# CITY OF ALBUQUERQUE

**RE: 1310 Cuesta Arriba Court NE**  
**Grading and Drainage Plan**  
**Engineer's Stamp Date: 02/03/20**  
**Hydrology File: D16D103**

Based upon the information provided in your submittal received 02/05/2020, the Grading and Drainage Plan is approved for Building Permit.

SHEET
GRADING
PLAN
C100

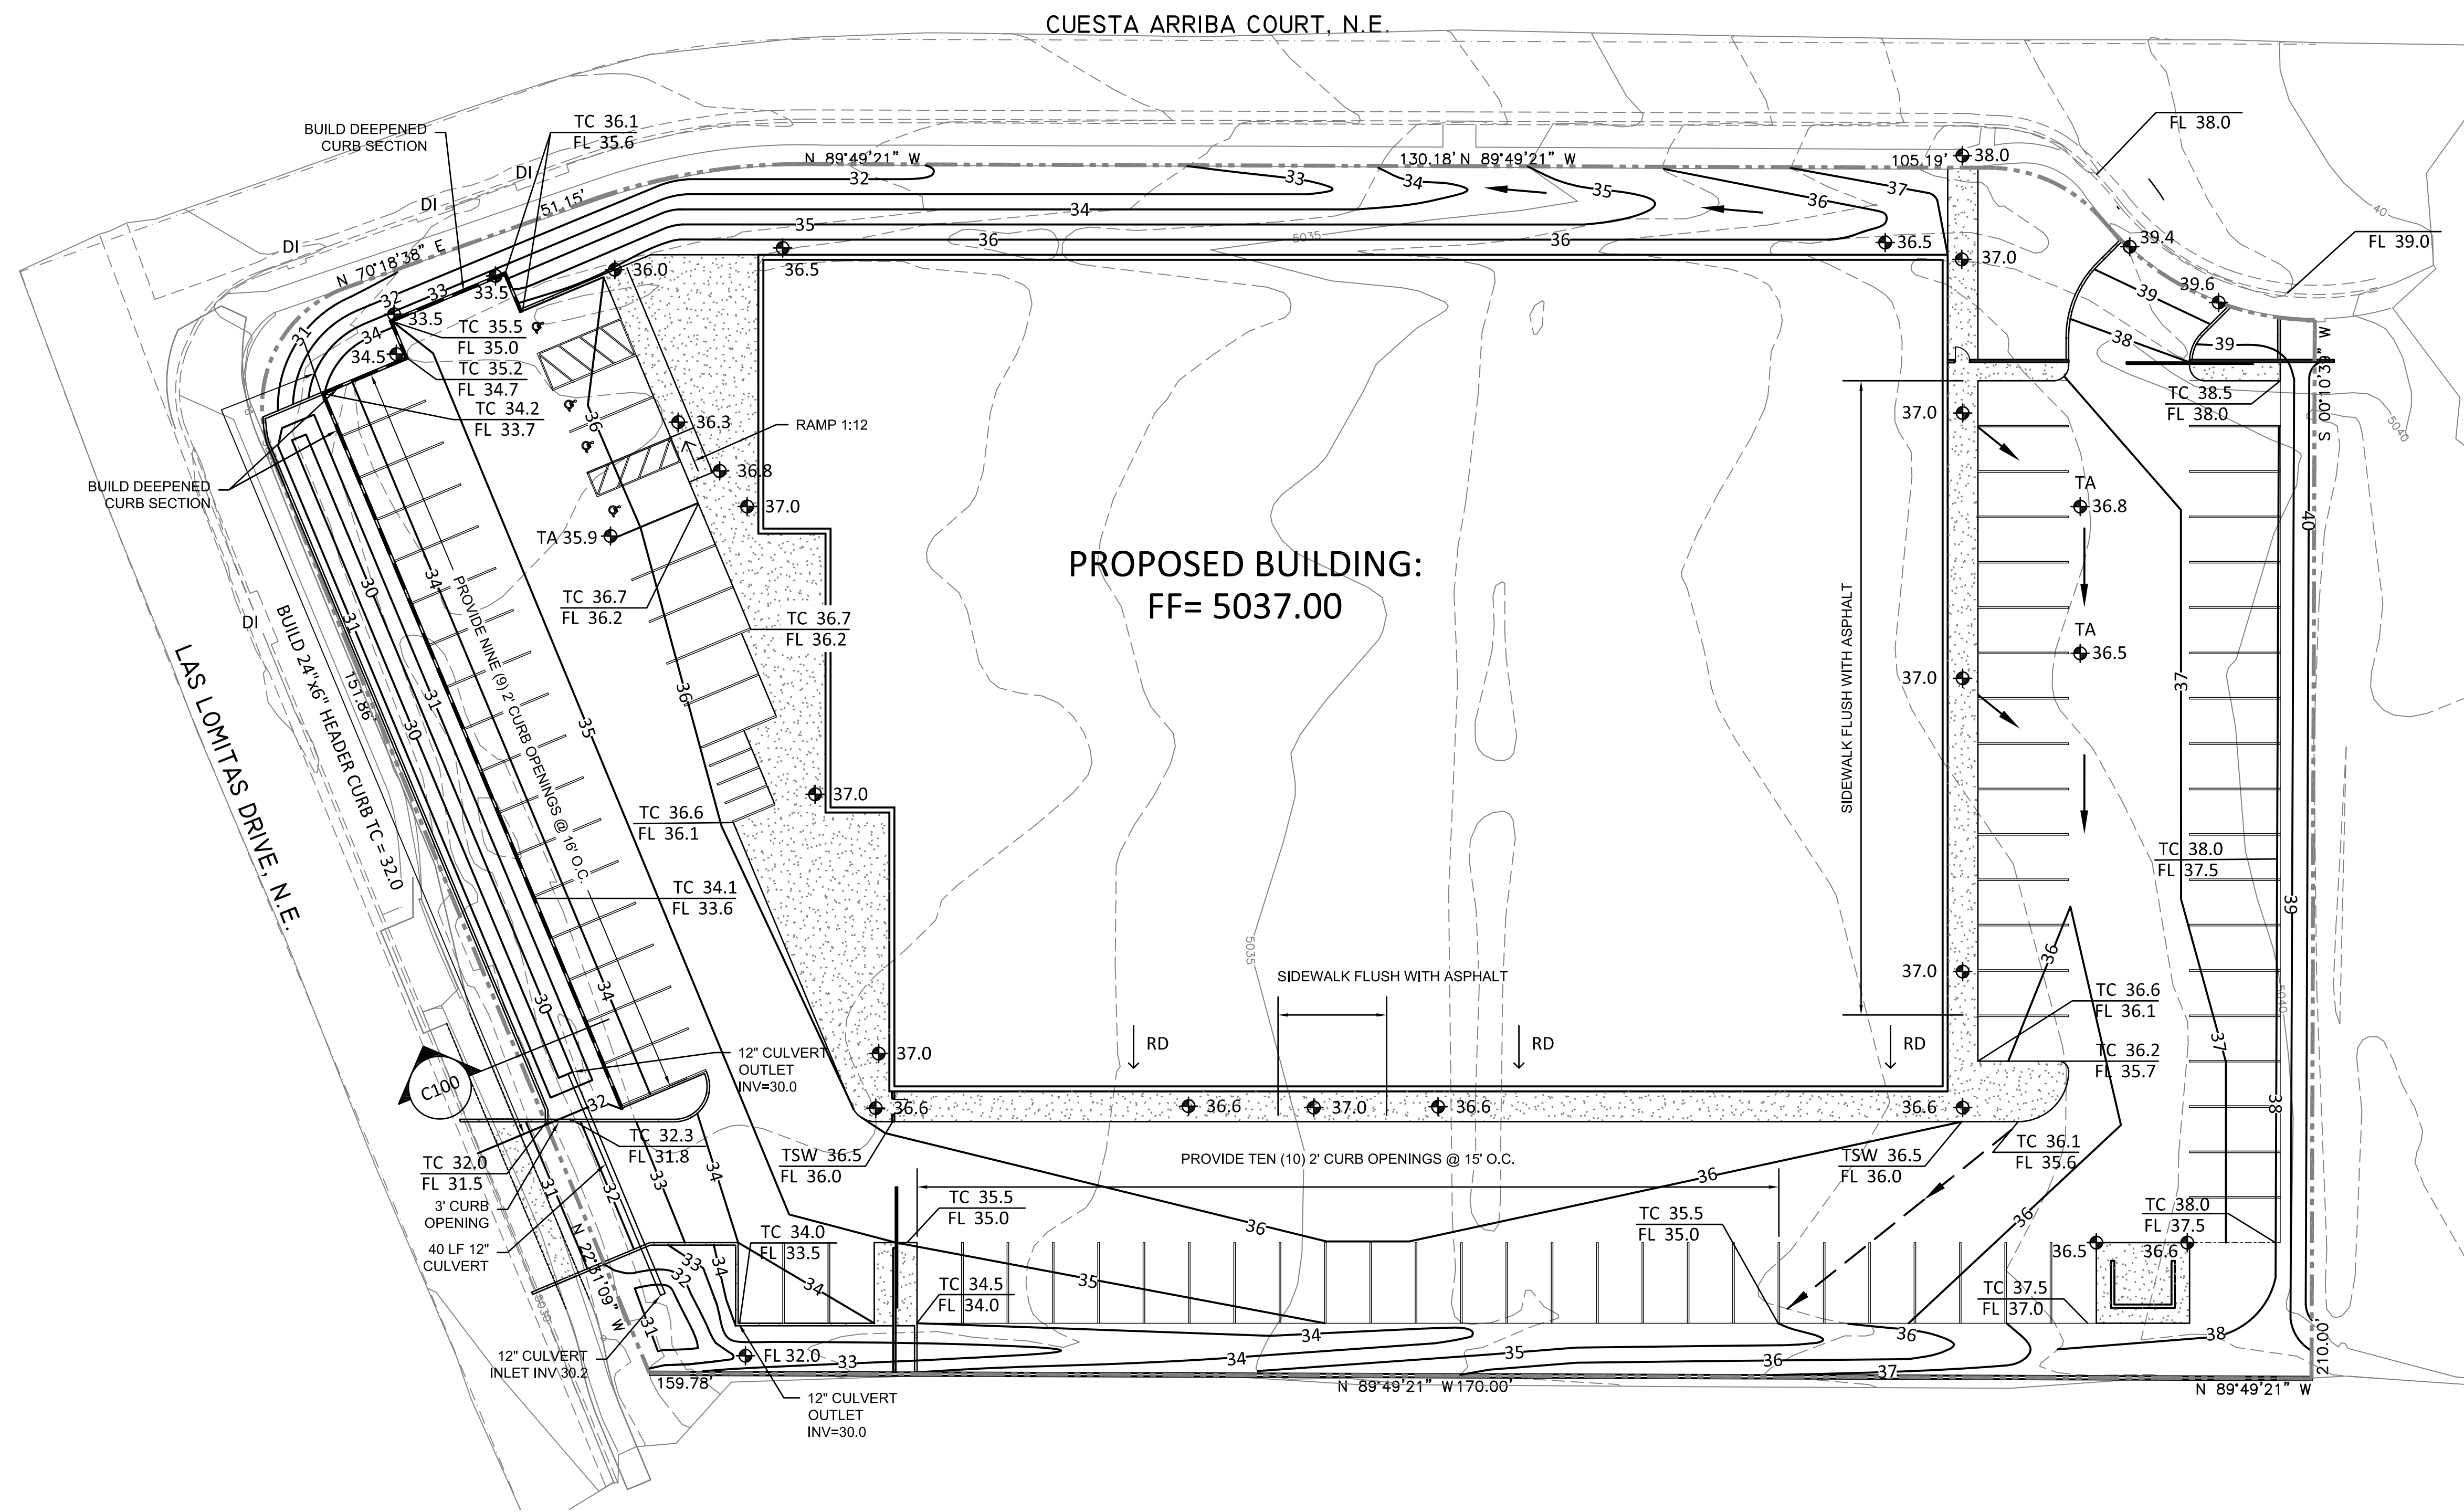
Also as a reminder, please provide a Drainage Covenant for the proposed stormwater quality ponds per Chapter 17 of the DPM prior to Permanent Release of Occupancy. Please submit this on the 4th floor of Plaza de Sol. A \$25 fee will be required.

Thank you for your review comments of December 12, which have been addressed as follows:

1. The existing transformer has been noted.
2. There is an existing sidewalk along Cuesta Arriba Ct NE.
3. Adjacent lot labels have been added. Field verification indicates the abutting residential private backyards are typically 4-12" below the grades along the existing south wall.

- 4-5. Site plan revisions have been made to address driveways and curbing.
6. Proposed contours have been revised per your comment.
7. A deepened curb detail has been added.

8. SWQ notations have replaced First flush labels as requested.
9. SWQ pond volume has been added.
10. An emergency spillway detail has been added showing a 3' curb opening where pond discharges to proposed west driveway.

11. Text callouts have been adjusted to be more legible.
12. Existing retaining wall label has been added along south side of site.
13. A section has been added for the south swale, wall, and parking lot.

14. SWQ volume indicated with WSE = 31.5 added to pond section.
15. Weir calculations have been added to the plan.
16. The roof plan has been revised and discharges 22,252 SF to the north. The 2 north side roof drains combine in an 8" drain line that carries flow west to the SWQ pond. No developed flows discharge to the north landscape area so no SWQ pond is required.
